Ribble Valley Borough Council
Council Offices
Church Walk,
Clitheroe
Lancashire
BB7 2RA

Phone: 0300 123 6780
Email: Kathryn.Walsh@lancashire.gov.uk
Your ref: 3/2024/1028
Our ref: 3/2024/1028/HDC/KW
Date: 31 March 2025

Location: Apple Tree Cottage 4 Orchard Cottages Branch Road Waddington
BB7 3HR
Proposal: Proposed single-storey side extension and internal alterations.
Grid Ref: 372959 443887

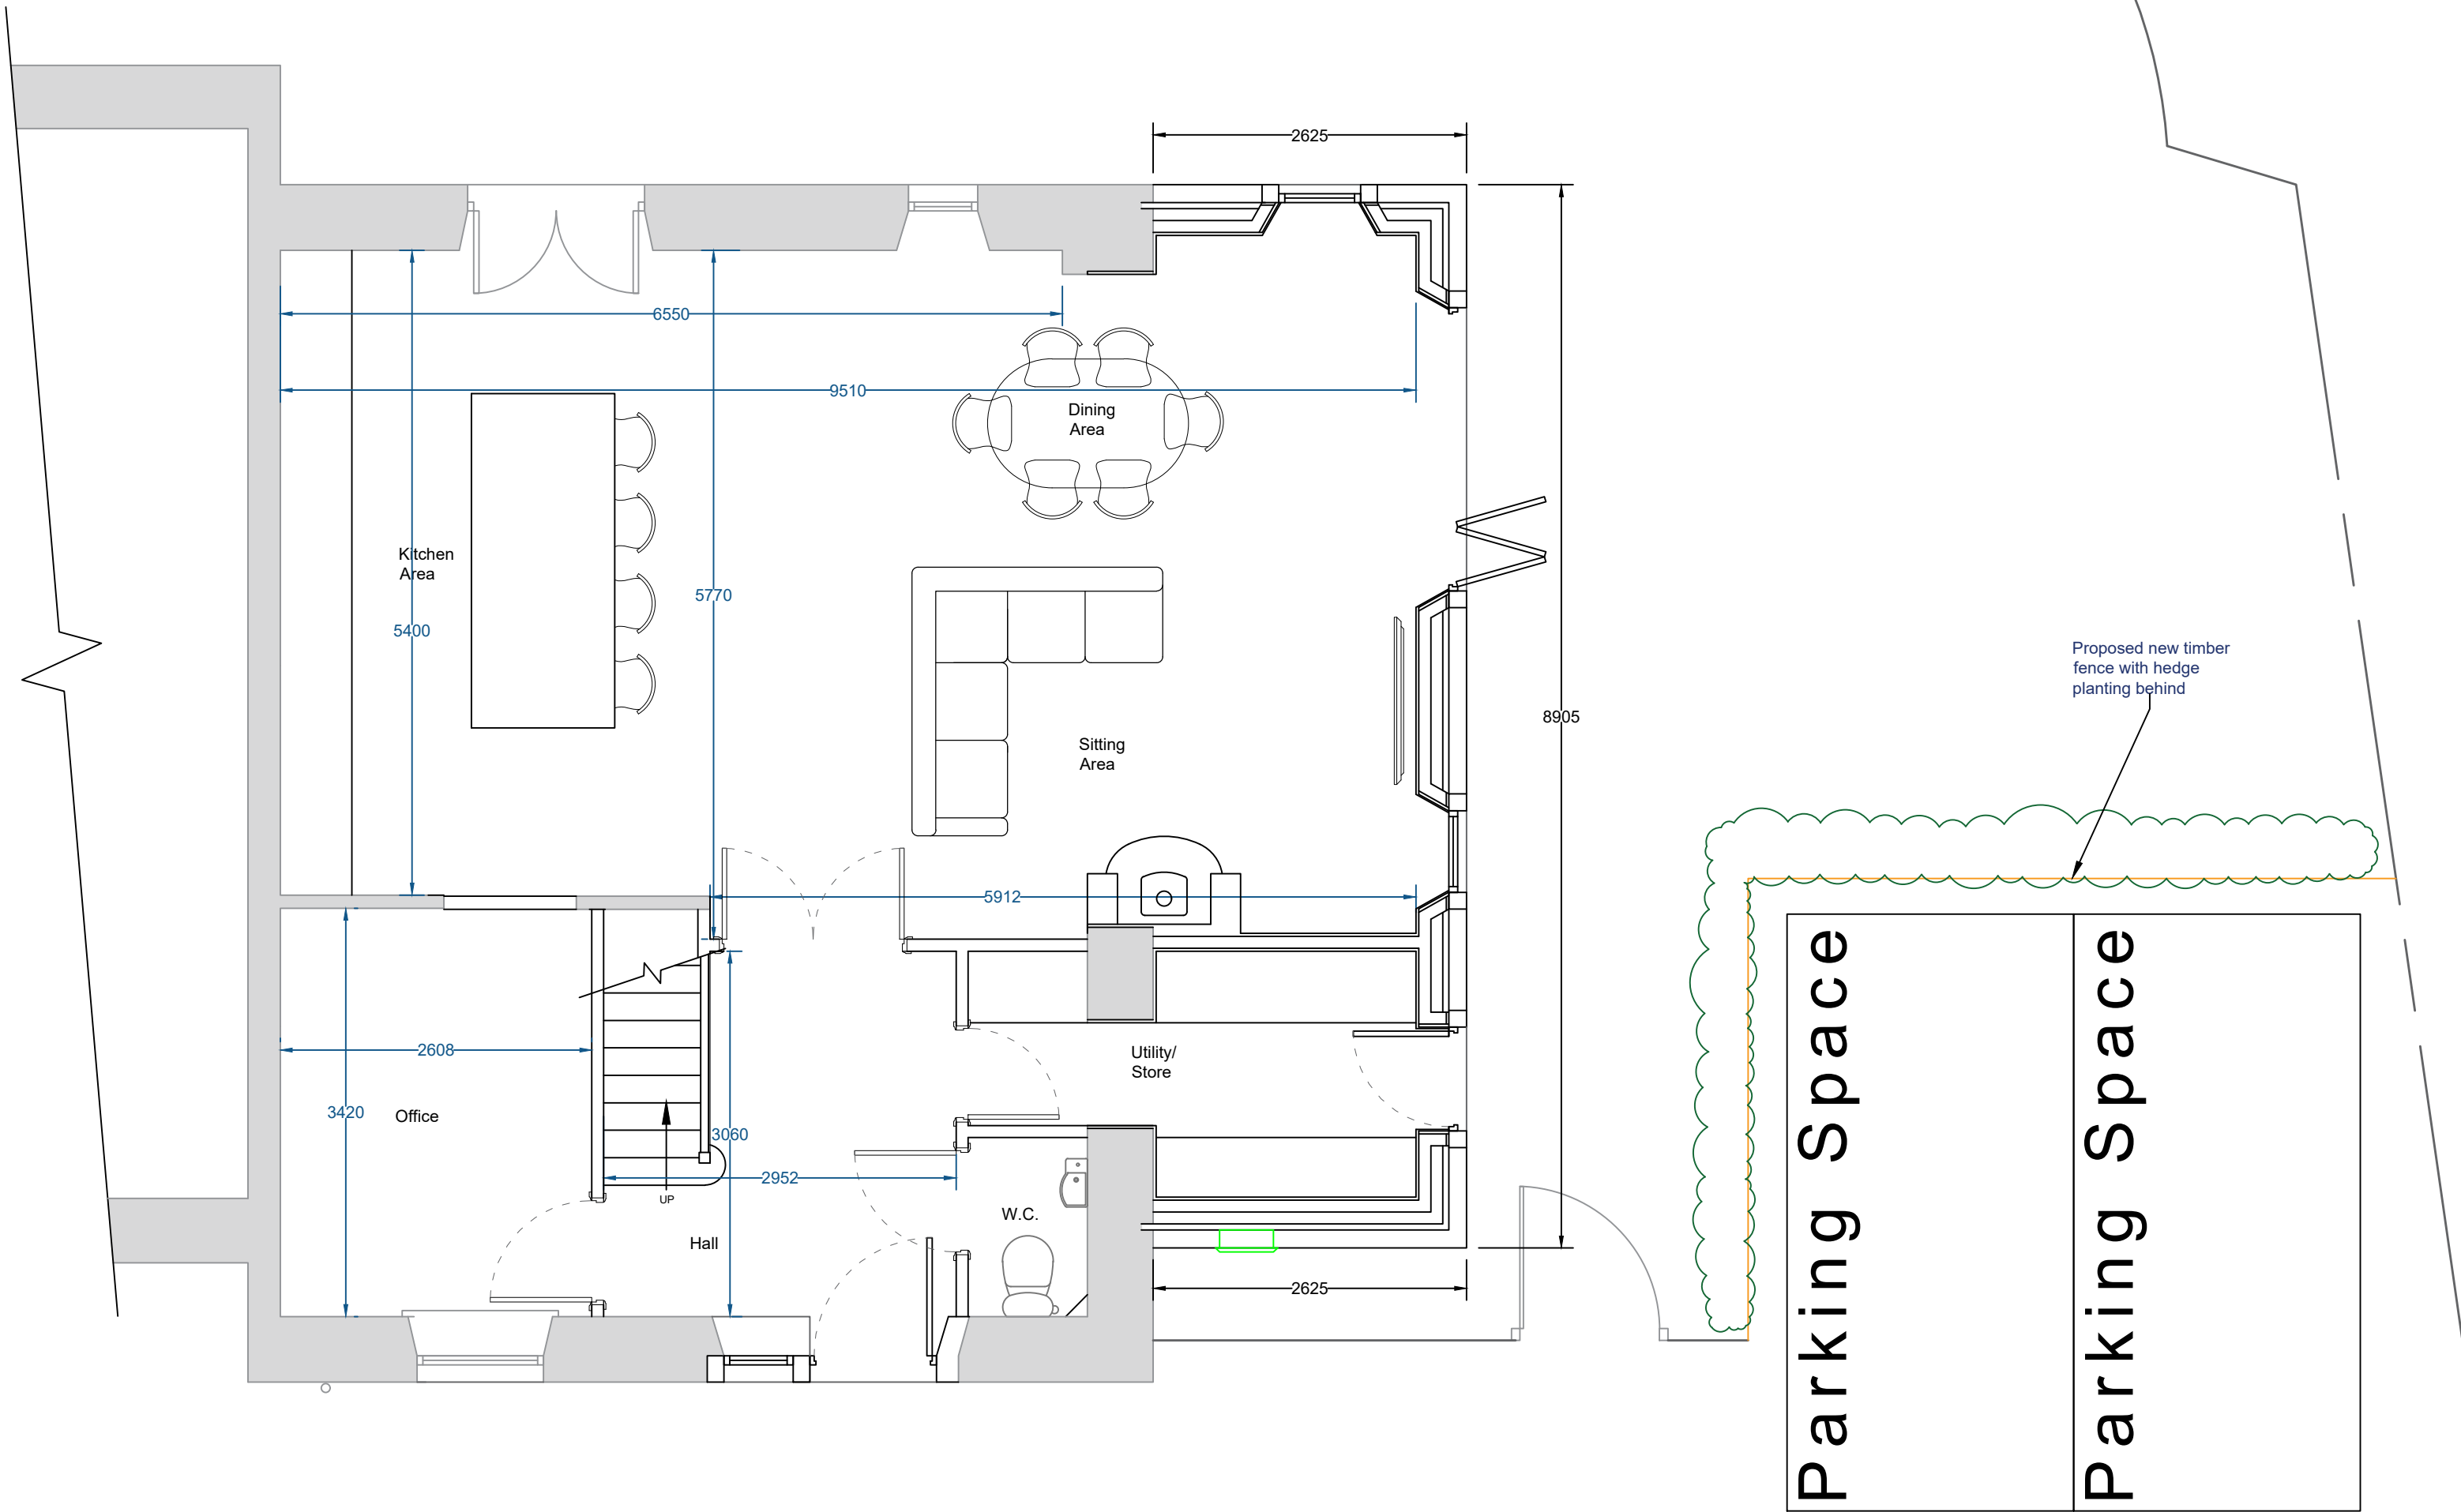
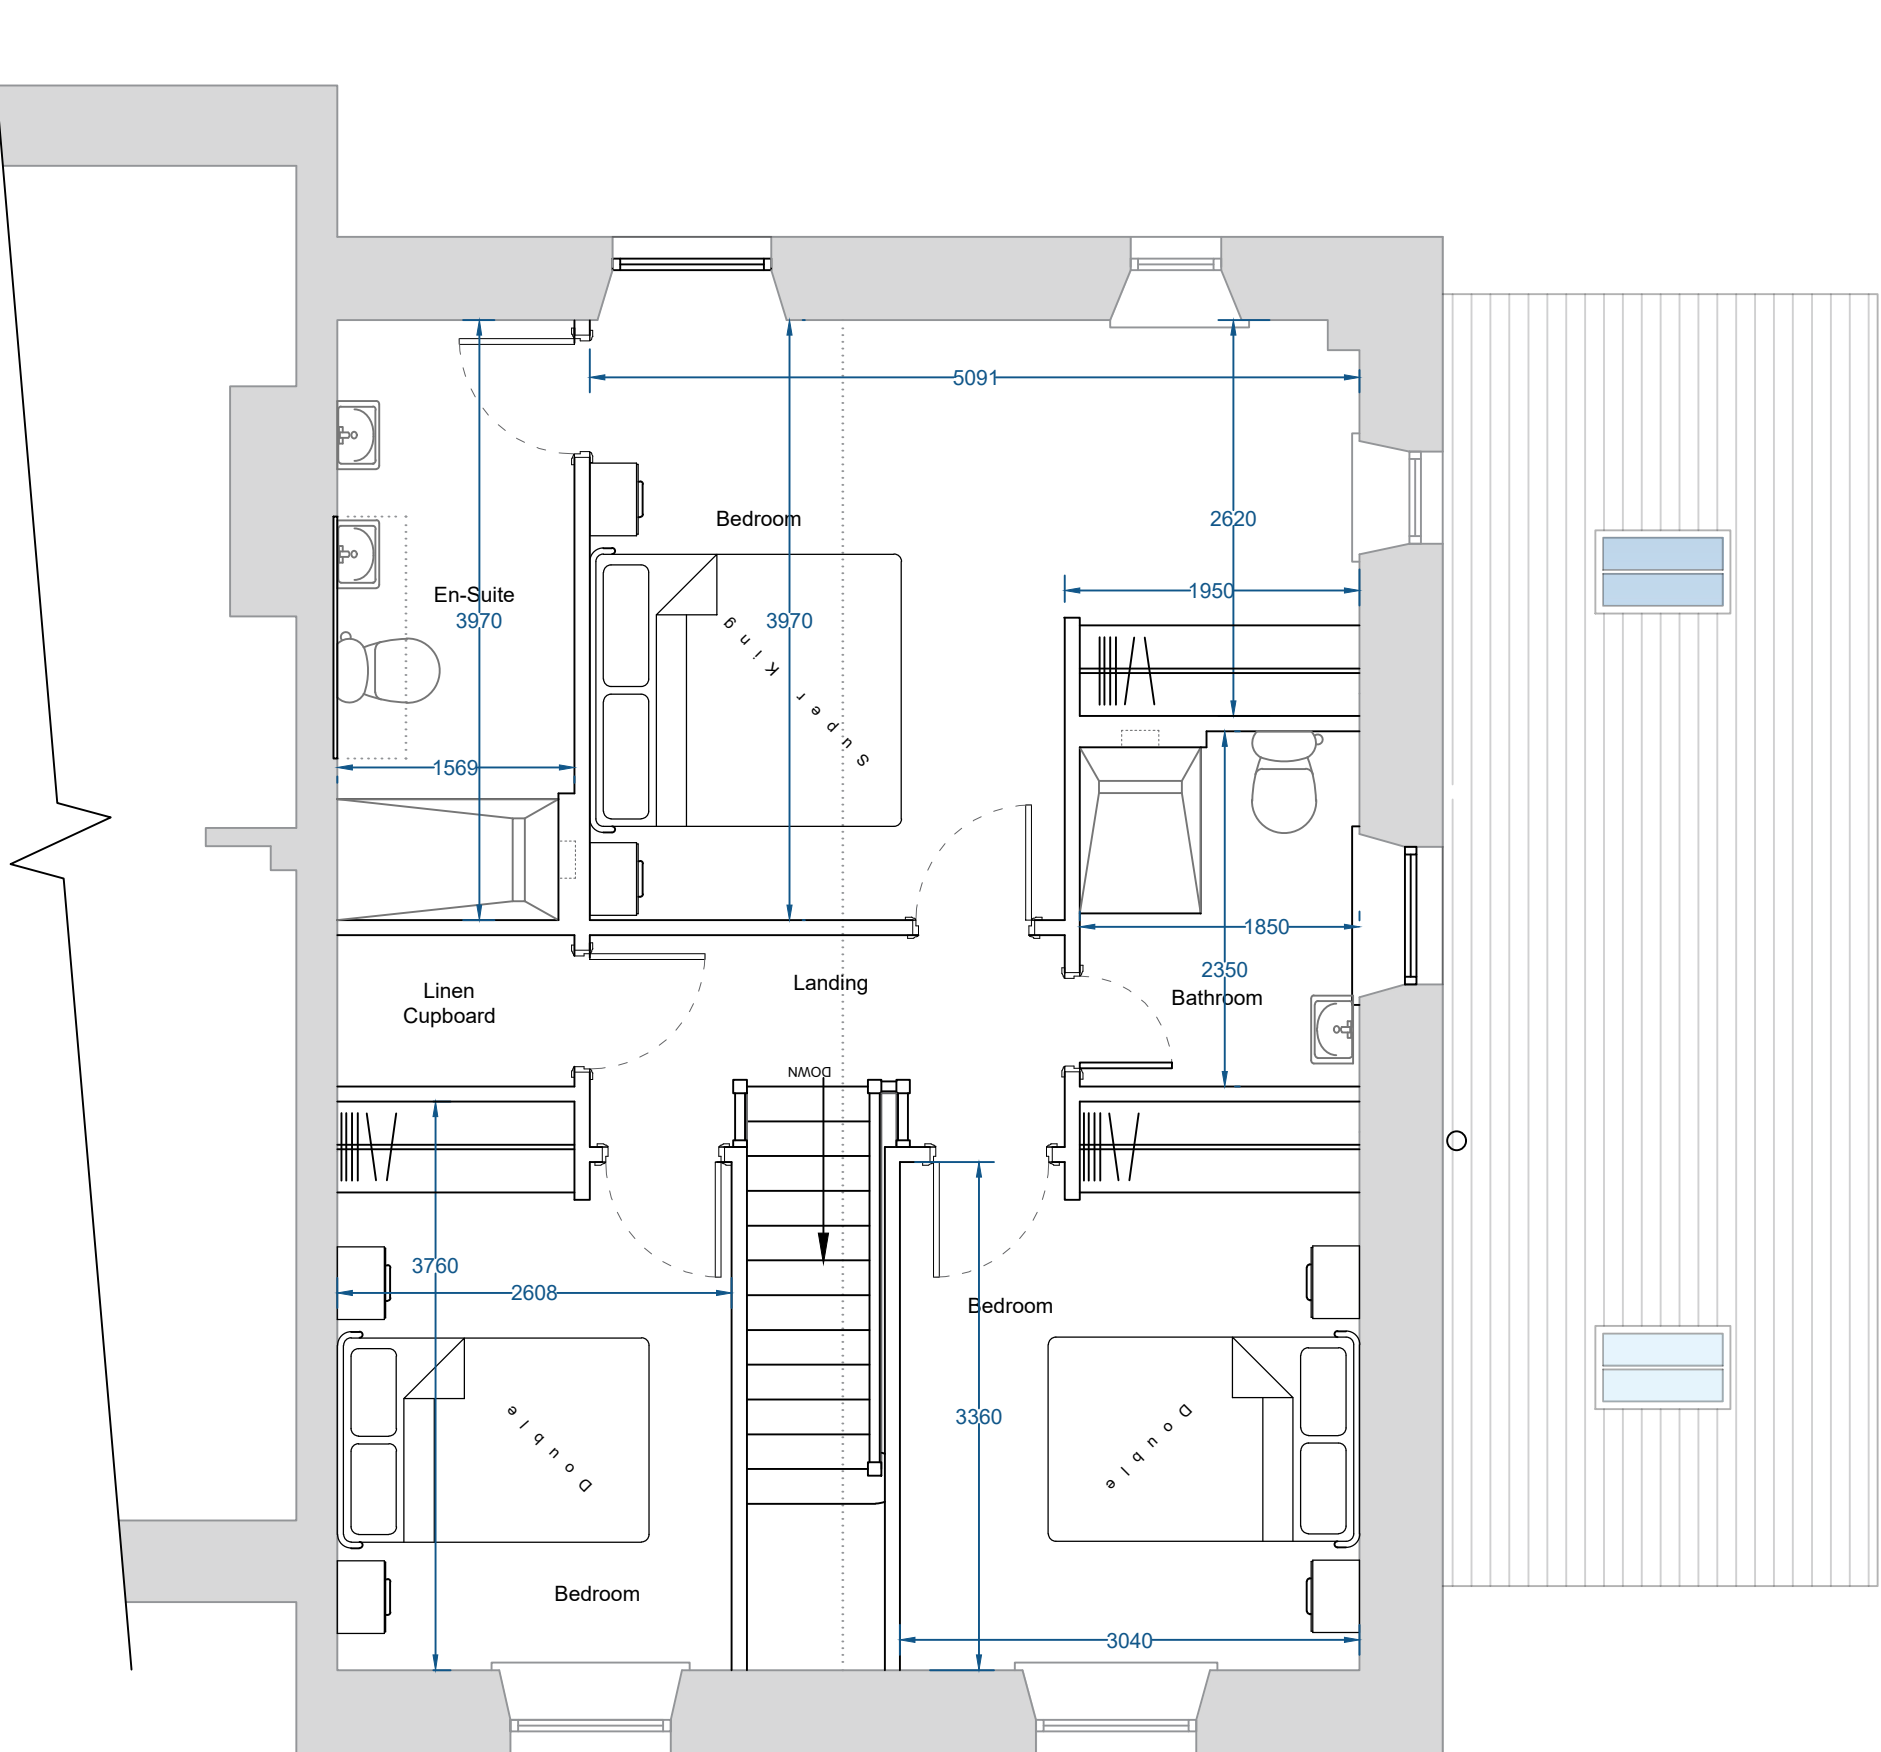
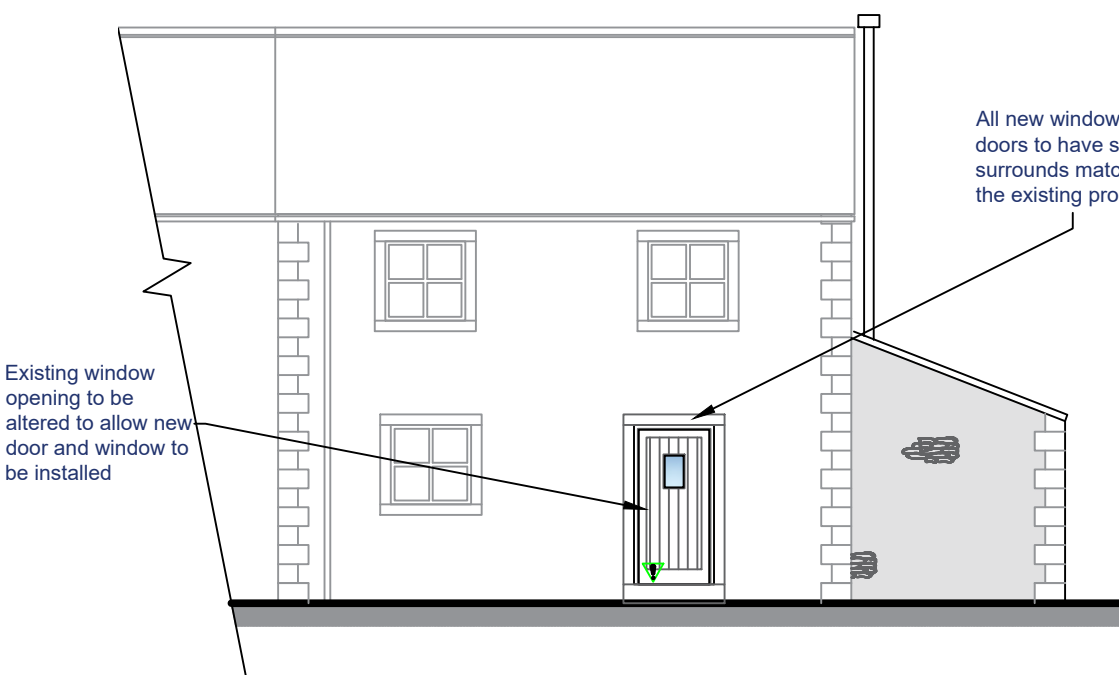
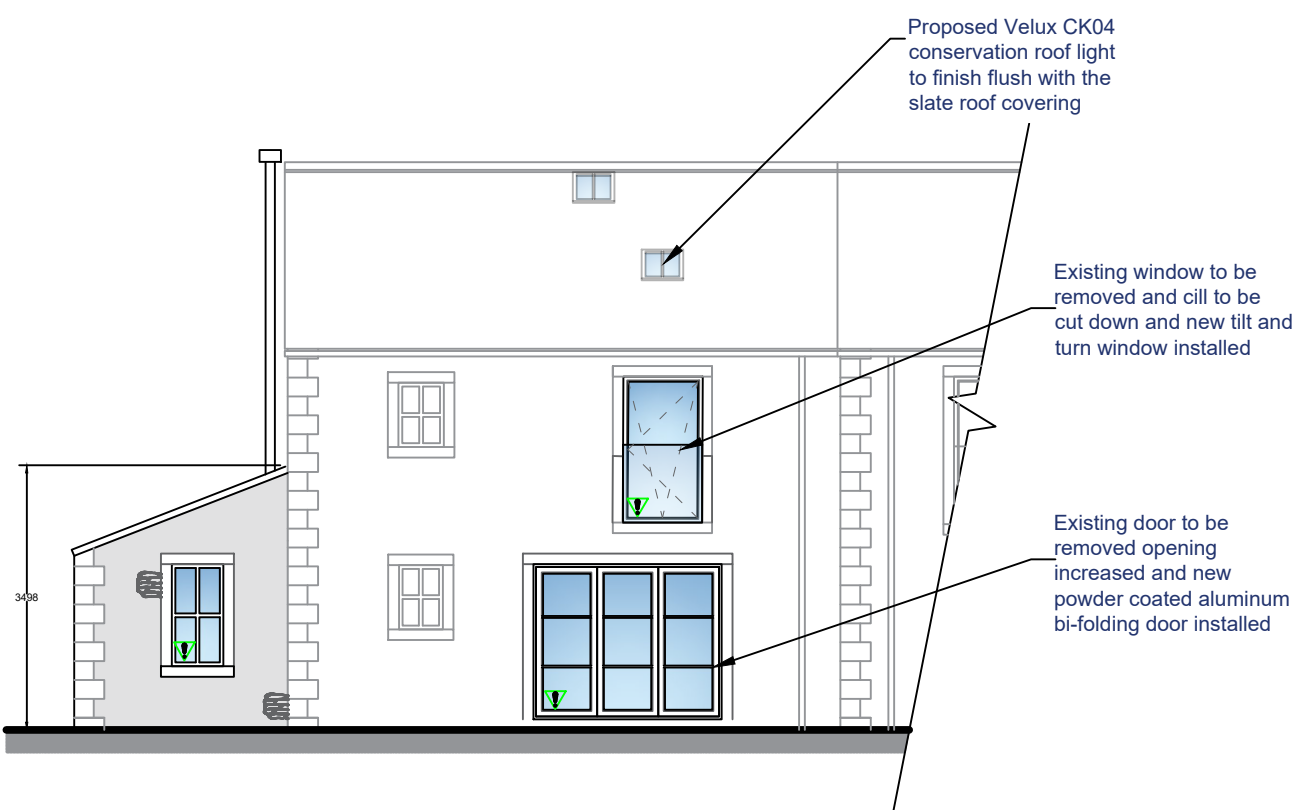
The LHA have reviewed drawing number 003 Revision D and note that there are 2 off street parking spaces which complies with the LHAs parking standards as defined in the Joint Lancashire Structure Plan.
